April 20, 2005

**Re: Chevron Corner Market, Palomas Avenue / San Pedro Drive NE, Site
Development Plan
Engineer's Stamp dated 4-07-05 (D18-D49)**

CONCEPTUAL GRADING AND DRAINAGE PLAN
CHEVRON GAS STATION 04-01-05
1" = 30'-0"

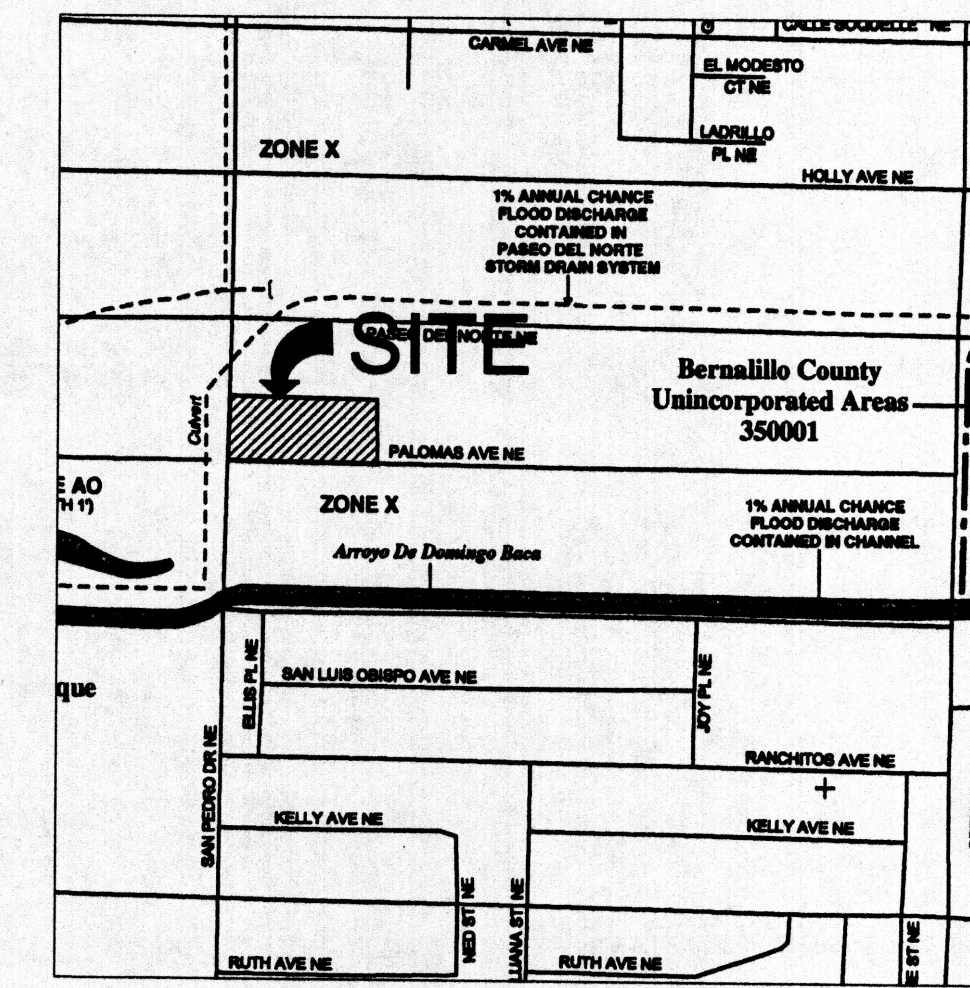
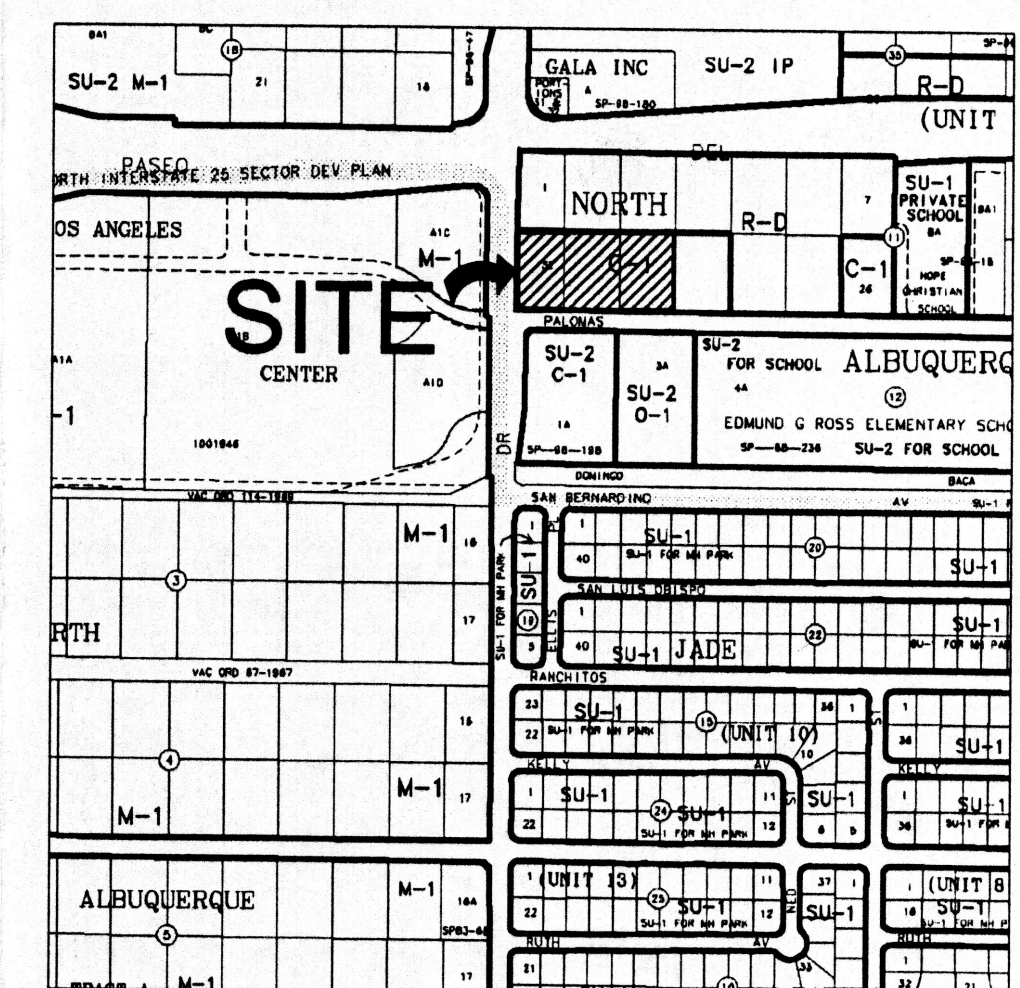
1. Clearly define which items will be built under work order. Will the proposed storm drain referred to in keyed note 9 be built under work order?
2. Provide invert elevations and details for all proposed drainage structures.
